From: Martyn White <Martyn.White@arun.gov.uk>
Sent: 07 June 2021 17:45
To: Planning.Responses <Planning.Responses@arun.gov.uk>
Cc: Maria Tomalova <Maria.Tomalova@arun.gov.uk>
Subject: BR/138/21/DOC

23 Mead Lane Bognor Regis PO22 8AP

Approval of details reserved by condition imposed under ref BR/175/20/PL relating to Condition Nos 3 - covered & secure cycle parking, 4 - brick bonding, 5 - new joinery details and 6 - rooflights.

PARTIAL PROPOSED NORTHERN ELEVATION

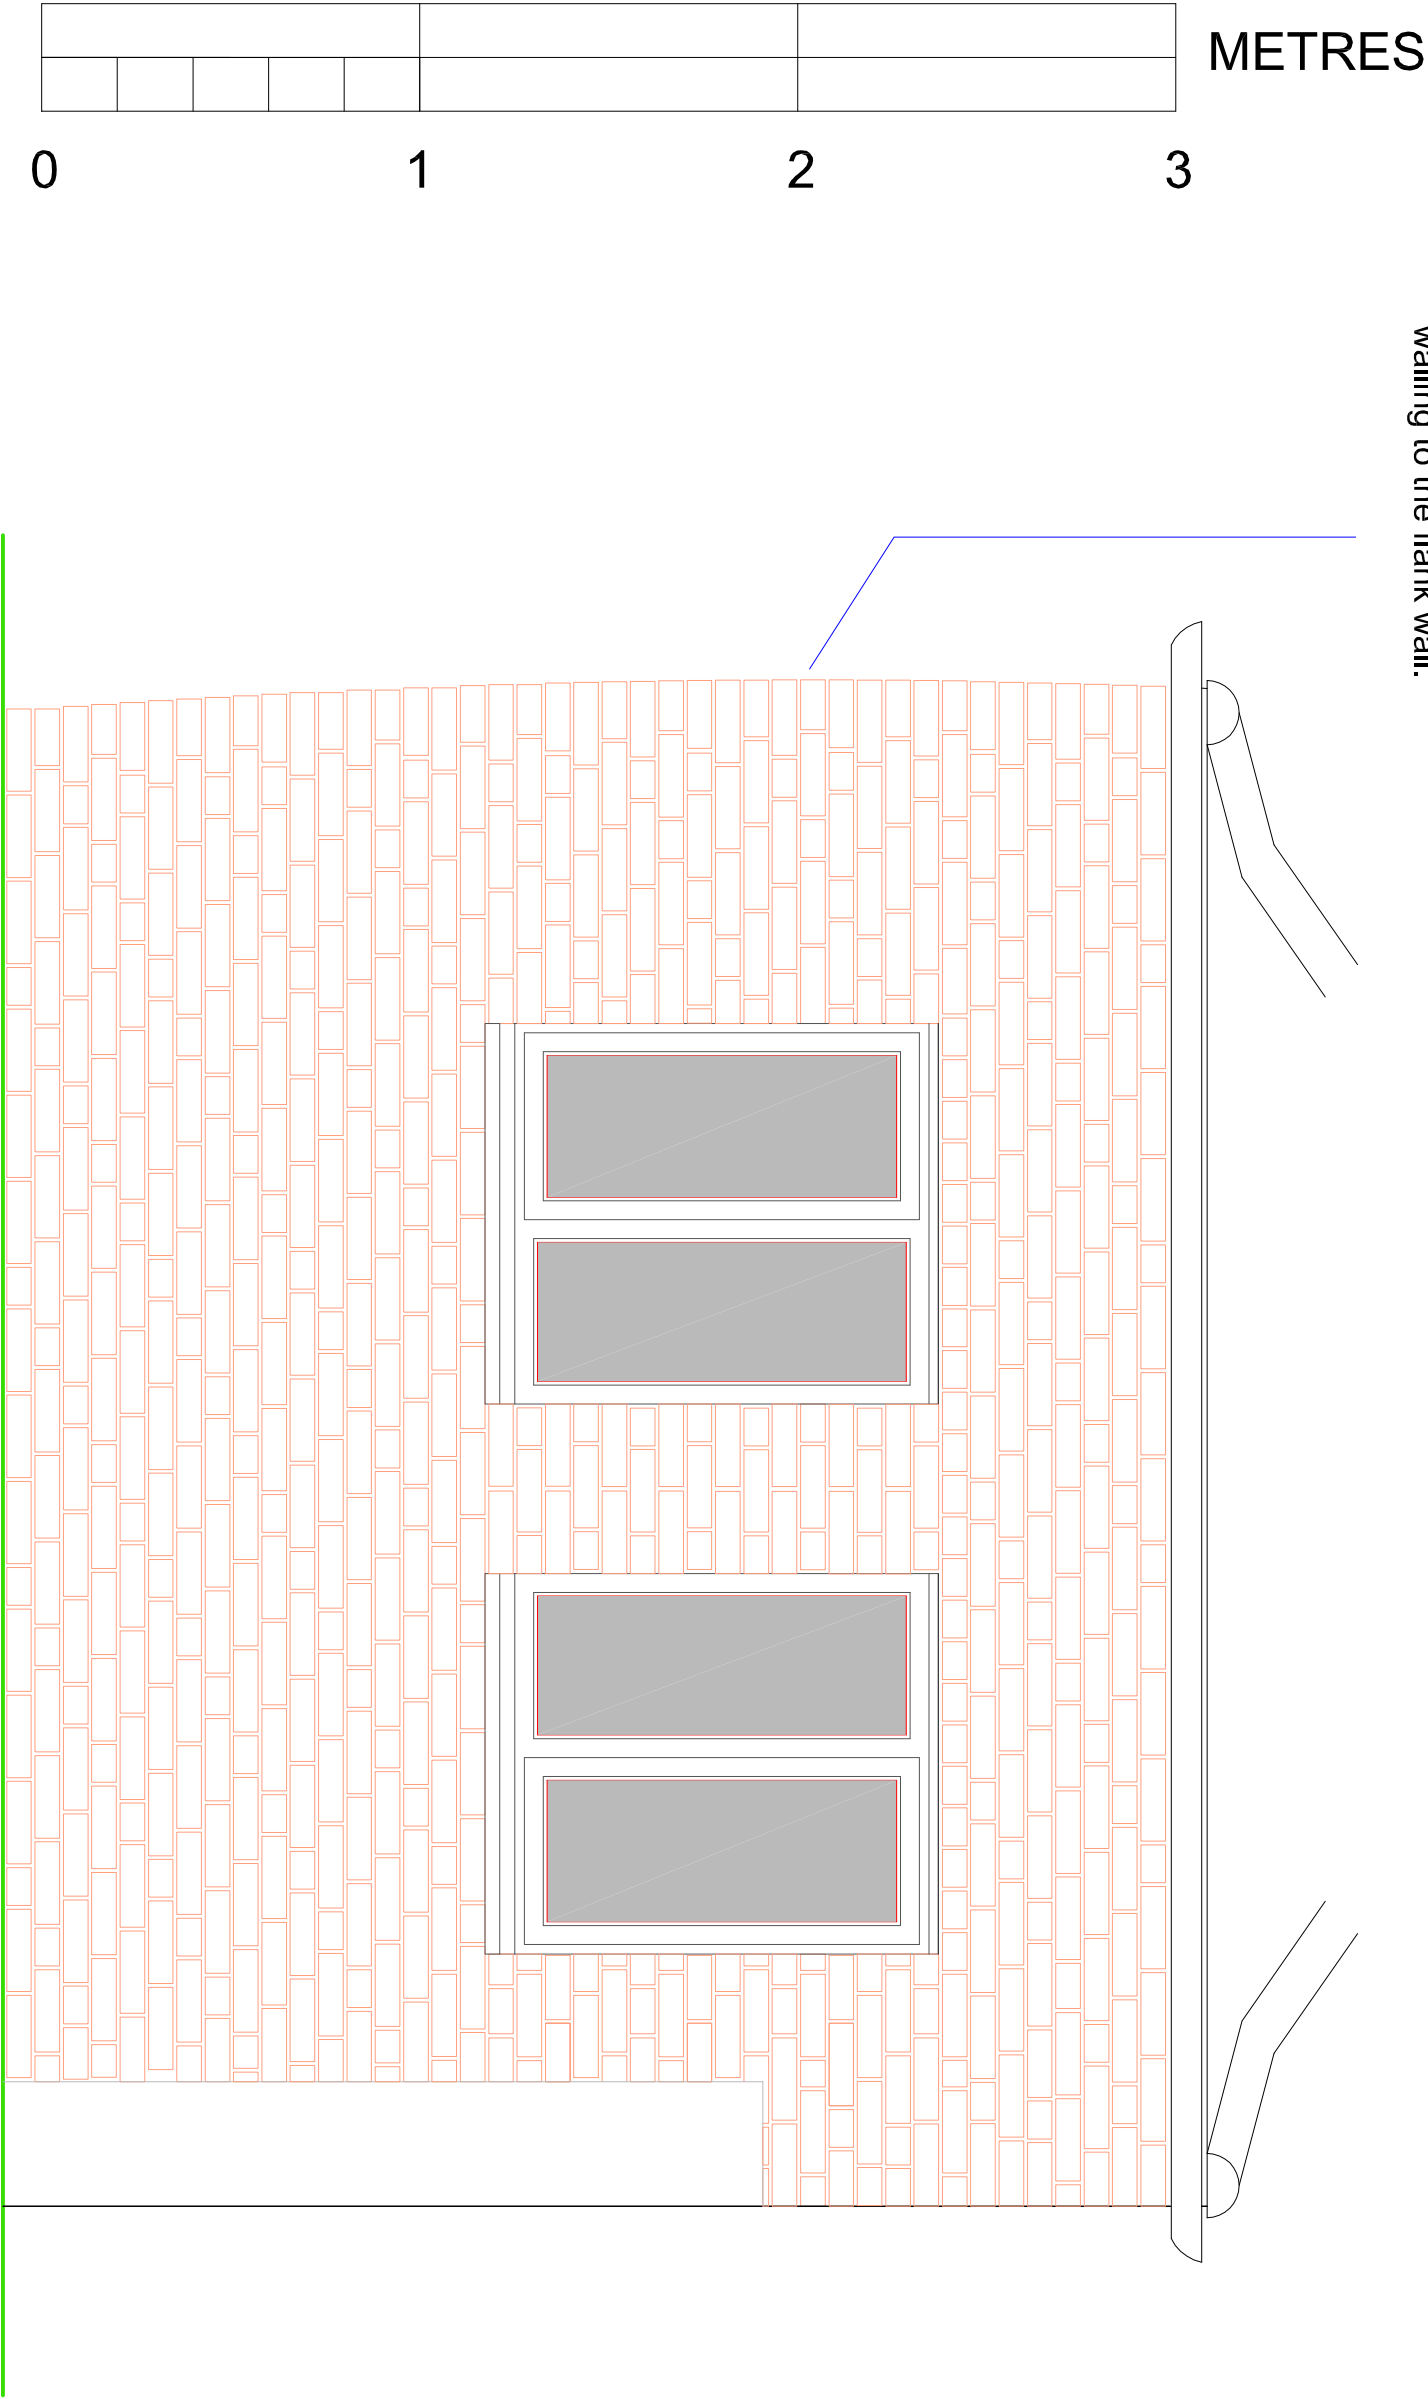
It would help to have it confirmed that any new bricks required to rebuild the section of wall on the northern elevation will match the existing.

DOOR DETAIL
(VERTICAL SECTION)

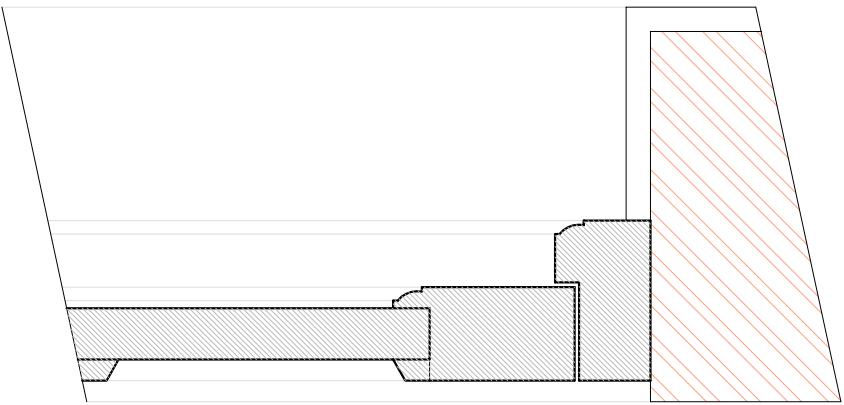
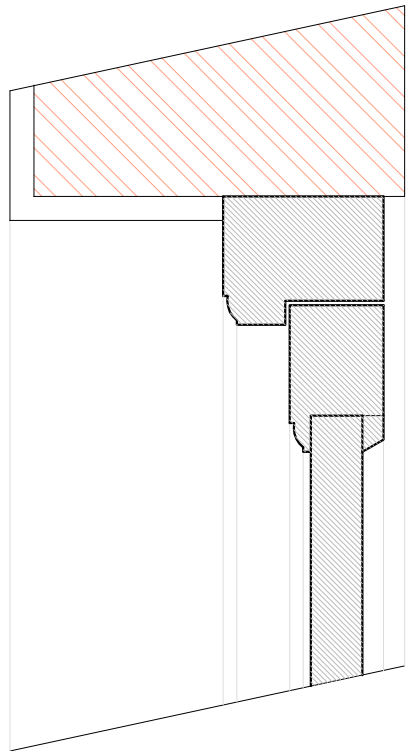
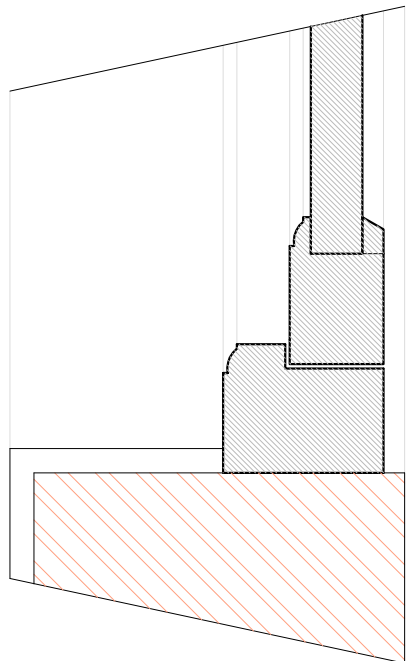
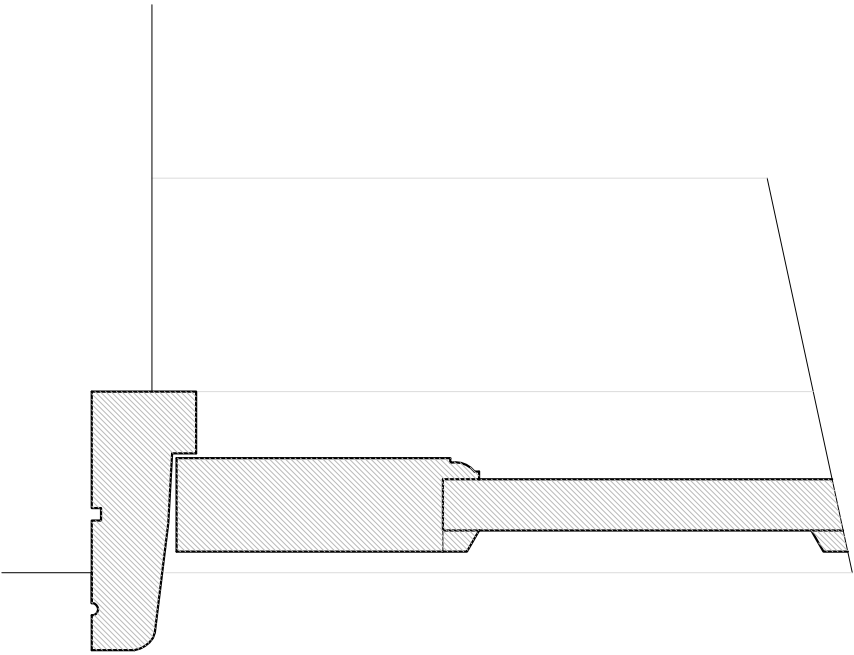
The proposed door which is shown on the southern elevation appears to be a standard type door, with an inbuilt 'fan style' window. This would be located under what looks like an existing fan light. I should point out that it does not appear on the section detail for the door and is not considered appropriate for the building. It is suggested that a more traditional design such as that proposed on the eastern elevation is more appropriate.
